**Consultation Response from Mike Hibbert,
KC Waste Strategy(Refuse & Recycling)**

2023/92926 Stiches, 10, Commercial Street, Batley, WF17 5HH

**Change of use from retail shop to hot food takeaway and installation of extract vent to rear
(within a Conservation Area)**

Responding Ref: WPN 23-062

**PROPOSED GROUND FLOOR PLAN**  
SCALE 1:50

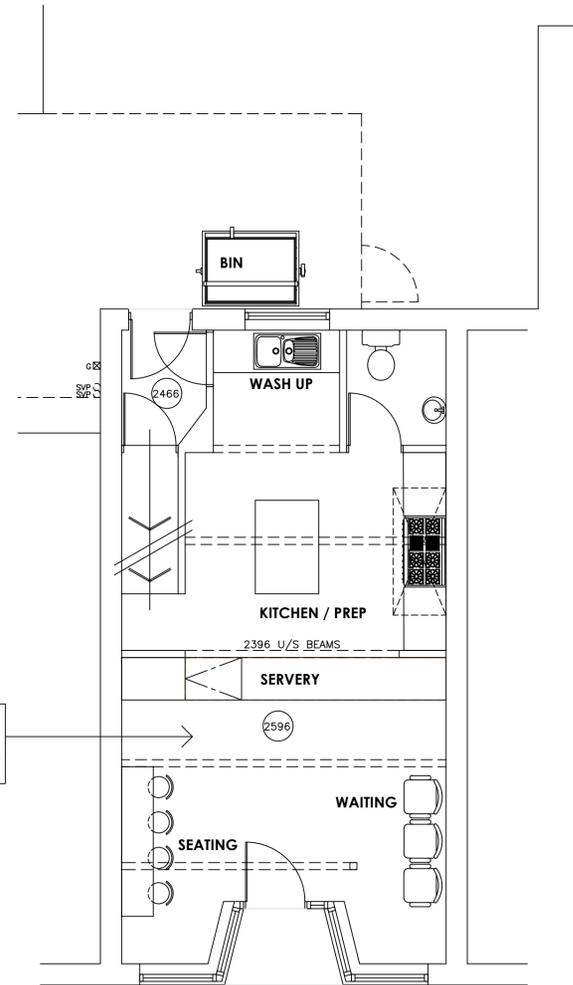
There are no details included in the application form relating to waste storage or management. The applicant has submitted a Drawing No 3846/01 dated September 2023 that shows a bin located to the rear of the premises.

It is not clear what the volume of waste generated at the site will be as this is dependent on the level of trade and packaging of supplies. Guidance indicates that typical waste generation is in the region of 1000ltrs per week.

- Separate wheeliebins will be required for residual waste, recycling (dry recyclables including cardboard and packaging), potentially separate food waste/Cat 3 animal by-products in addition secure storage of used cooking oils/ fats.

- The bins should be contained within a purpose designed store. Details of bin store construction requirements including screening can be found in the Kirklees Waste Management Design Guide 2020. The bin store should be secure to prevent theft, unauthorised use/ fly tipping, arson or rough sleeping.

- Bin store surfaces should be durable and waterproof enough to withstand heavy duty cleaning such as power washing. The storage area needs to have suitable drainage.

- A temporary Bin Collection Point (BCP) for use on the collection day should be shown on the site plan. It appears that the closest highway is Hannover Place at the rear of the premises. The drag out distance for wheeliebins from a Bin store/ premises to the collection vehicle should preferably be under 15m.

- The bin storage area and access routes to the Bin Collection Point (BCP) should be constructed to withstand point loading and movement, impacts of larger bins over time, and to resist future rutting, pitting, cracking, or other such surface degradation that would impair bin manoeuvring. The route should avoid kerbs.

- Provision should be made to collect litter generated by customers.
- Waste management for the development will need very careful consideration to prevent negative impact on surrounding premises. Full details of the site layout and design must be addressed.
